CITY OF ALBUQUERQUE

Re: Crestline
2635 Baylor Dr. SE
Traffic Circulation Layout
Engineer's/Architect's Stamp 08-07-19 (M16-D044)

Based upon the information provided in your submittal received 09-04-19, the above referenced plan cannot be approved for Building Permit until the following comments are addressed:

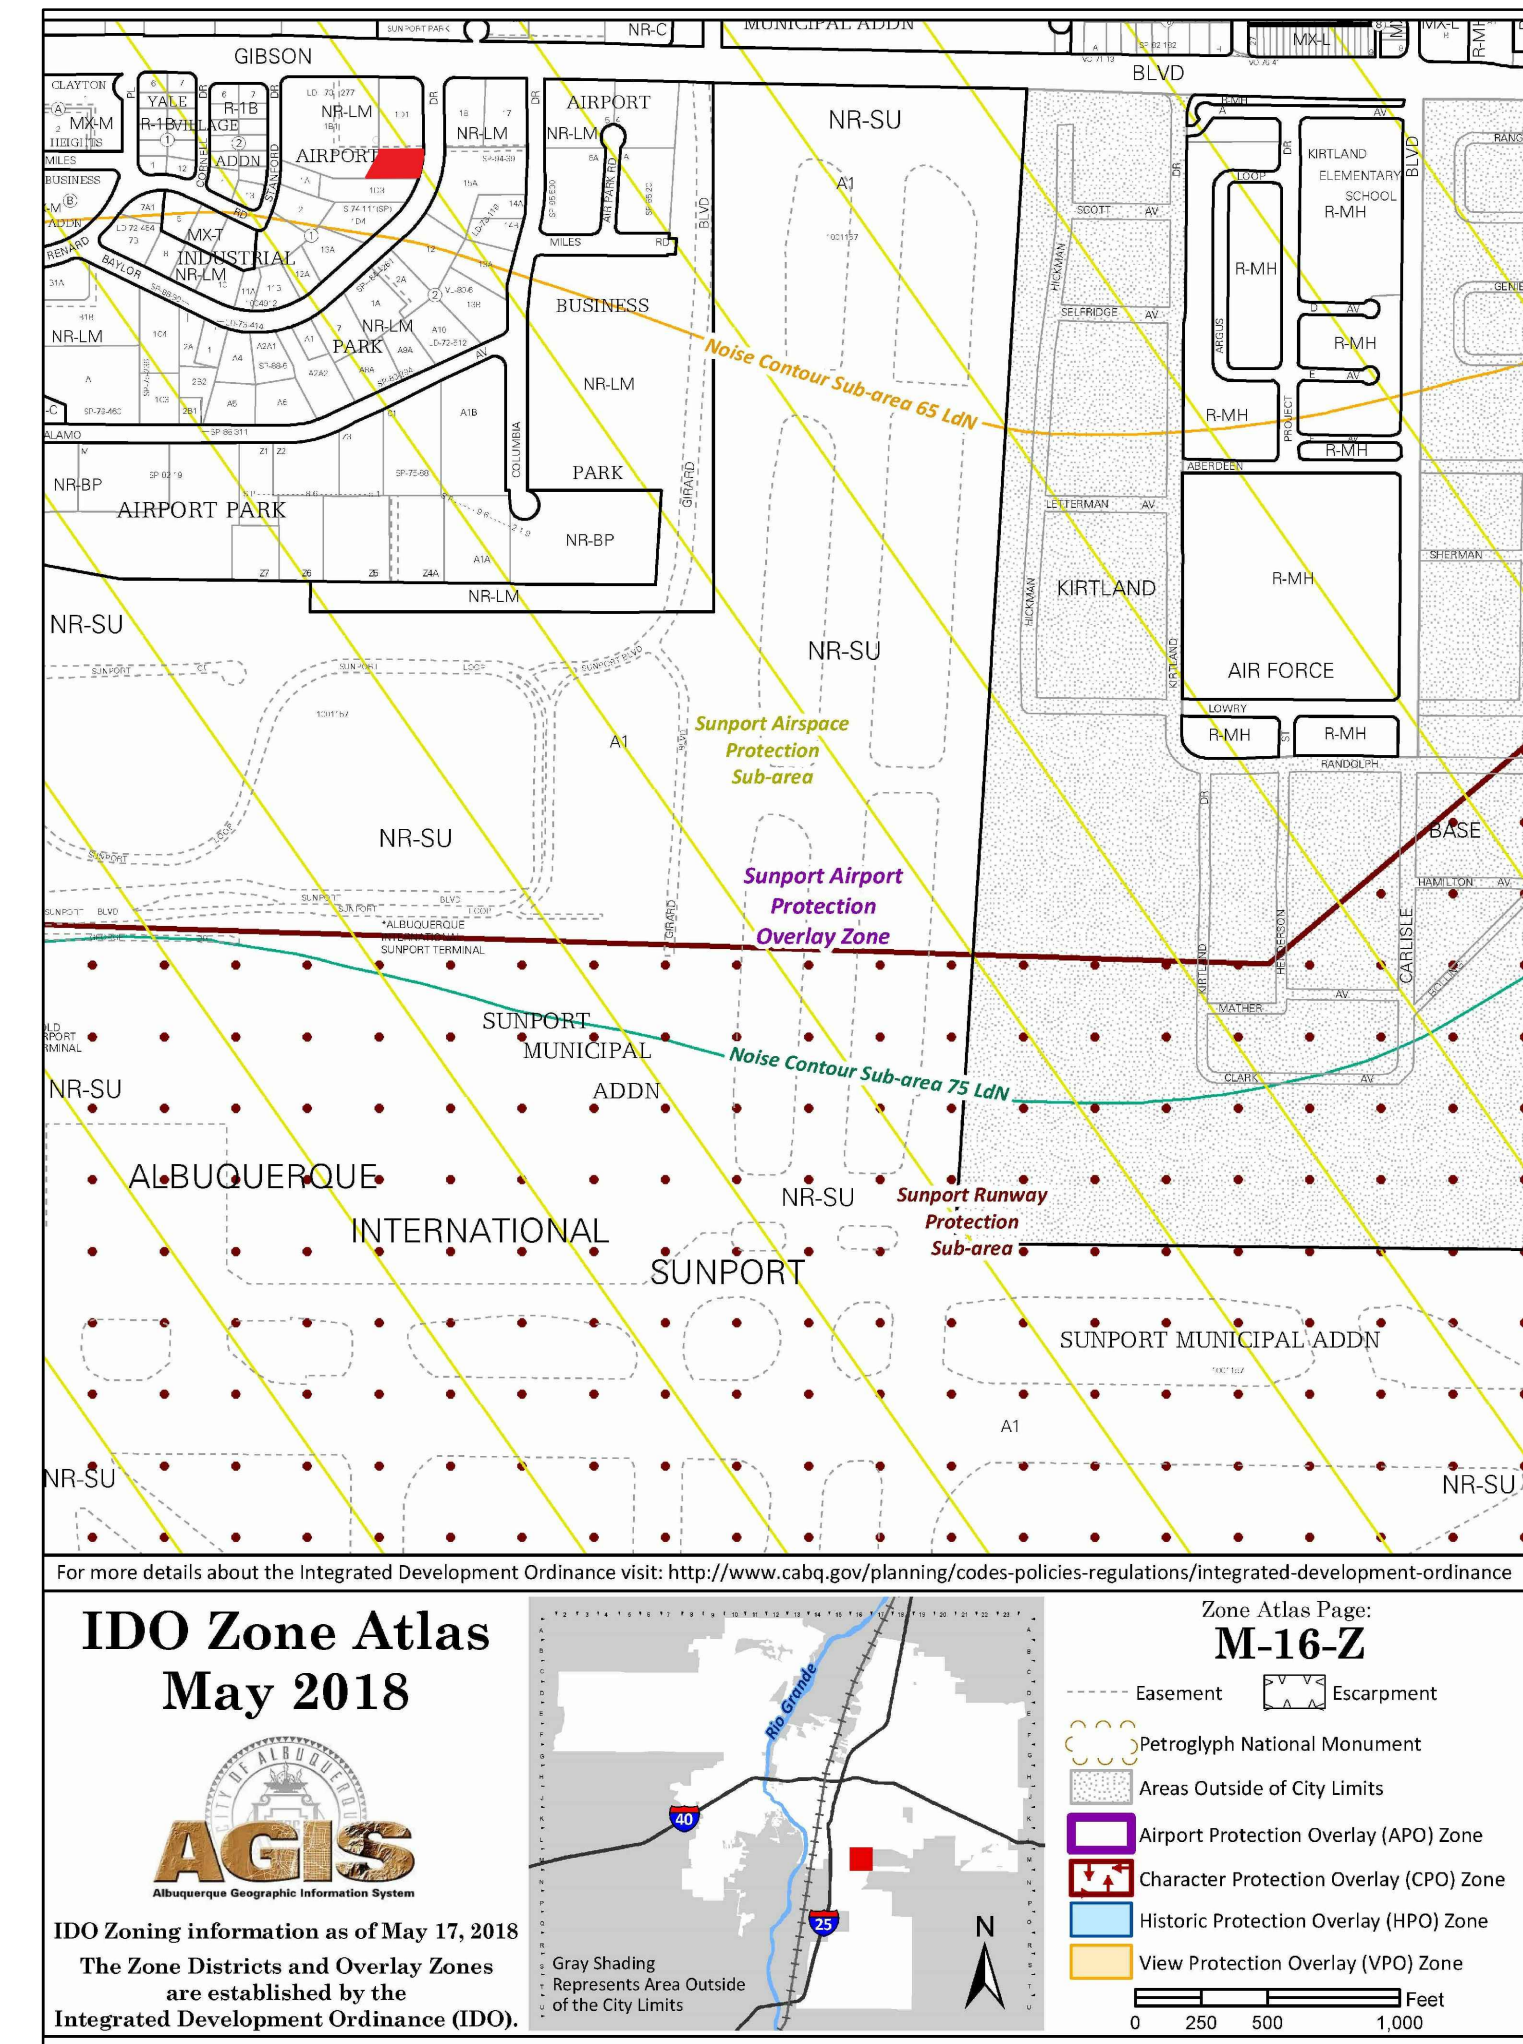
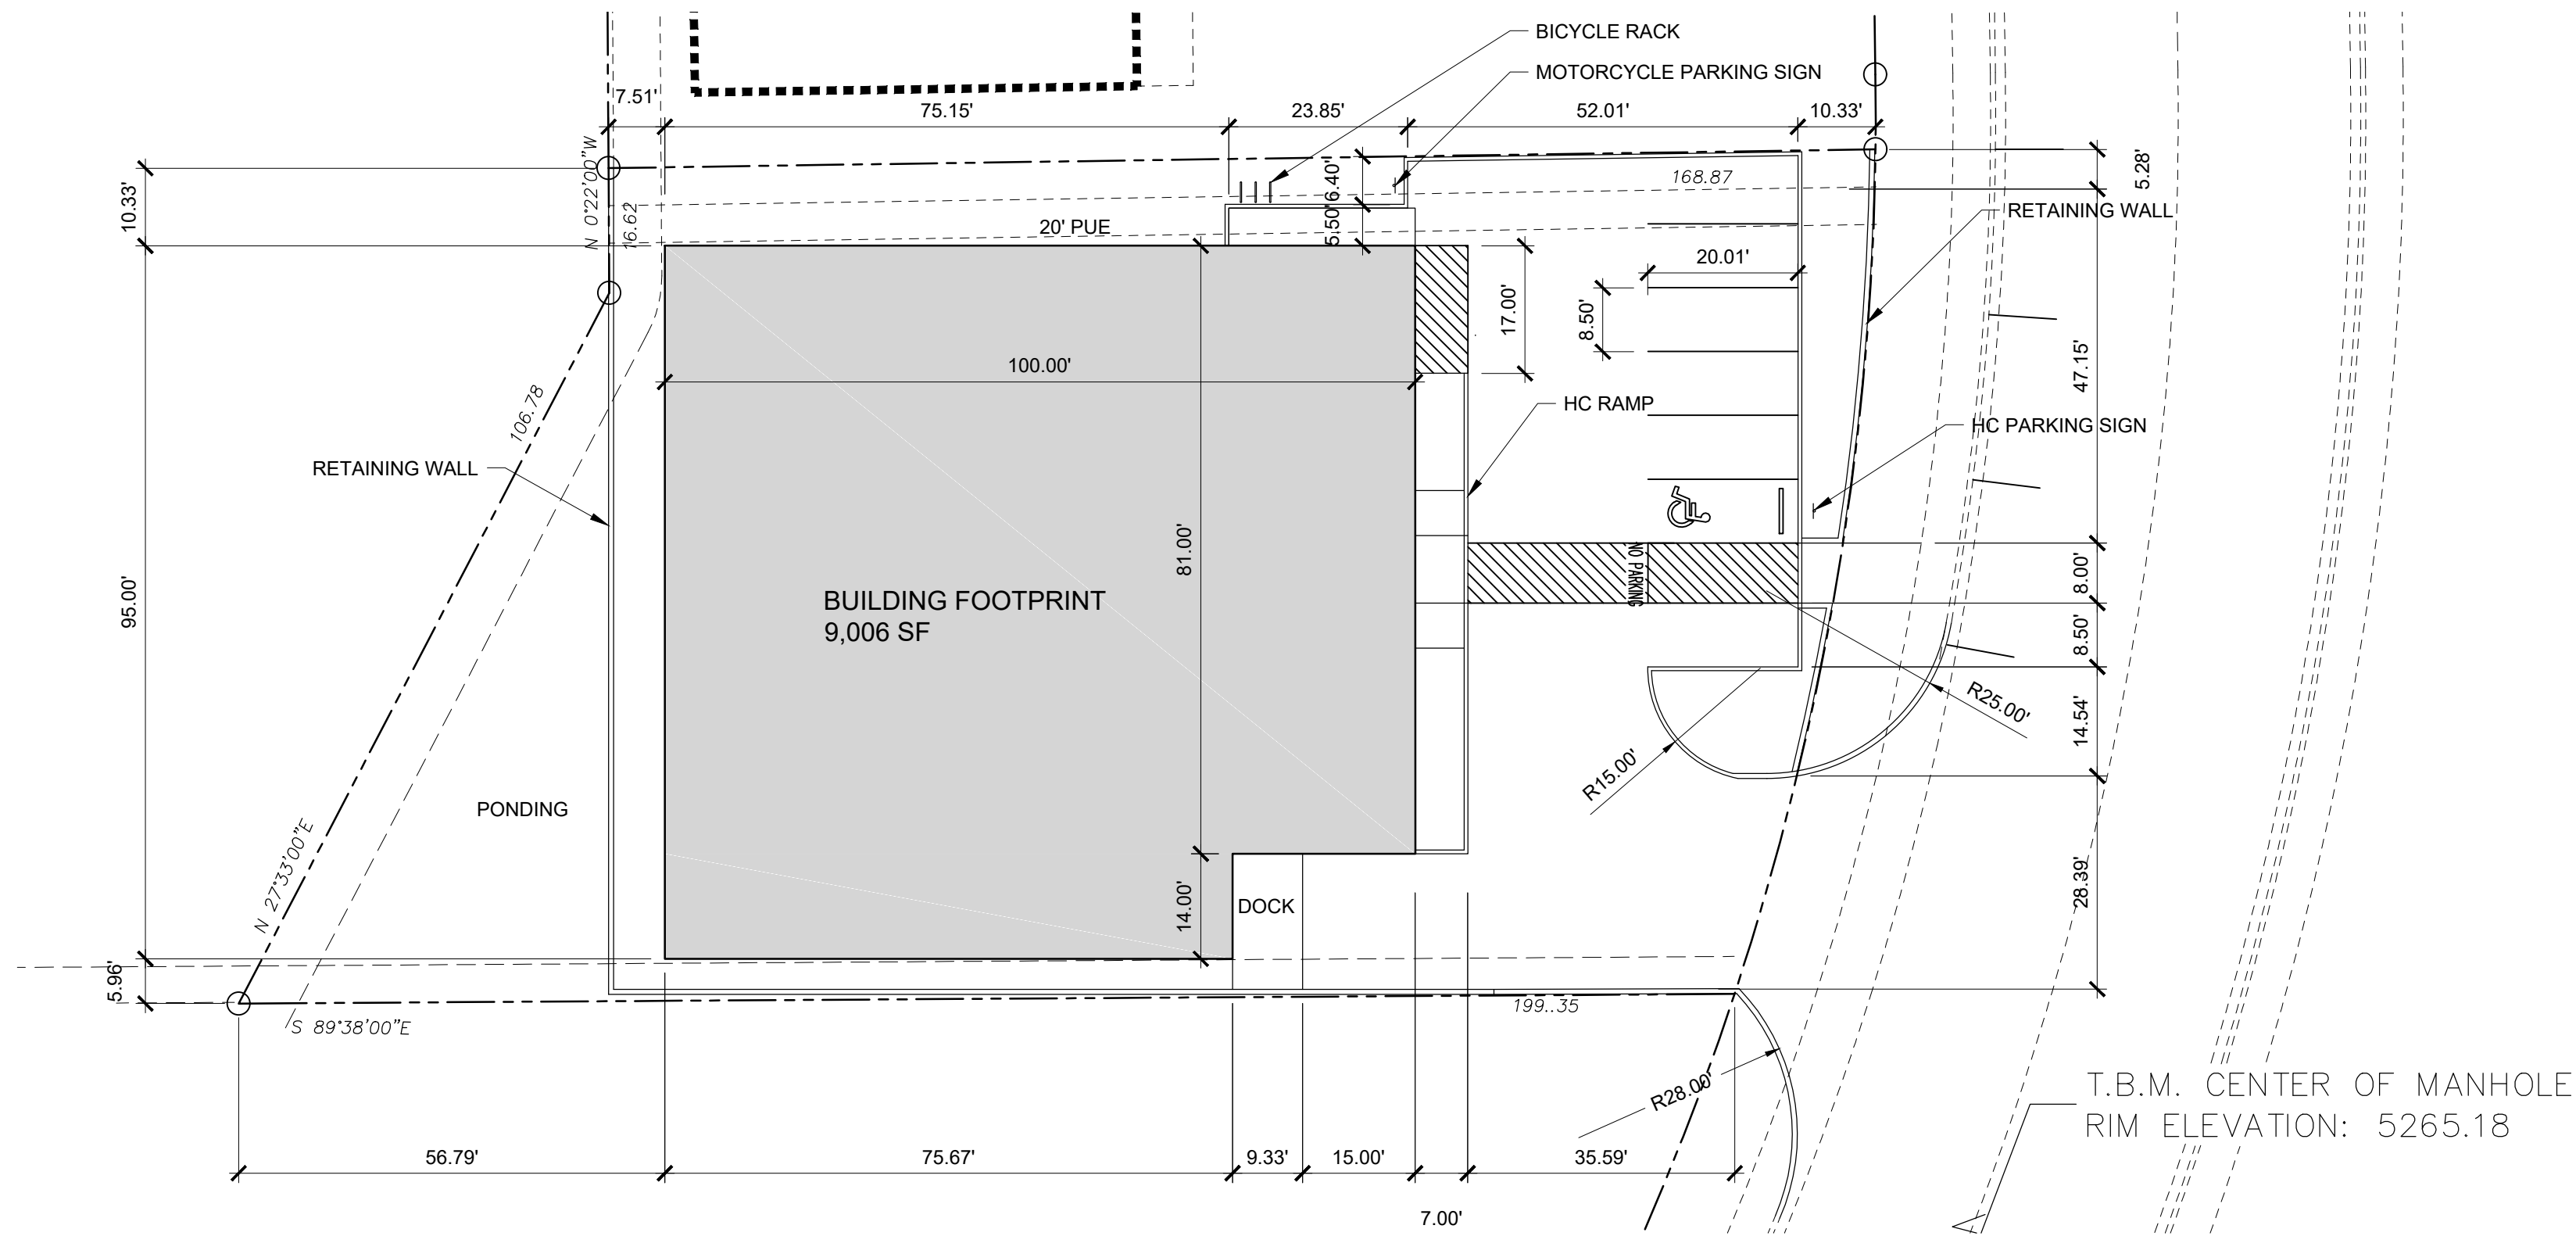
1. Identify the right of way width, medians, curb cuts, and street widths on Street(s) Name.
2. Show grade in the parking area specifically the ADA space.

3. Show all drive aisle widths and radii. Some dimensions are not shown.
4. Refuse vehicle maneuvering shall be contained on-site.The refuse vehicle shall not back into the public right of way.; provide a copy of refuse approval.

5. Show the clear sight triangle and add the following note to the plan:
"Landscaping and signage will not interfere with clear sight requirements. Therefore, signs, walls, trees, and shrubbery between 3 and 8 feet tall (as measured from the gutter pan) will not be acceptable in the clear sight triangle.

6. The existing curb cut is bisected by the property line as shown on AGIS website. Please clarify. Is the access you are showing is a new access?
7. Please show the existing sidewalk and curbe and gutter and show how you are tying it with your proposed curb.
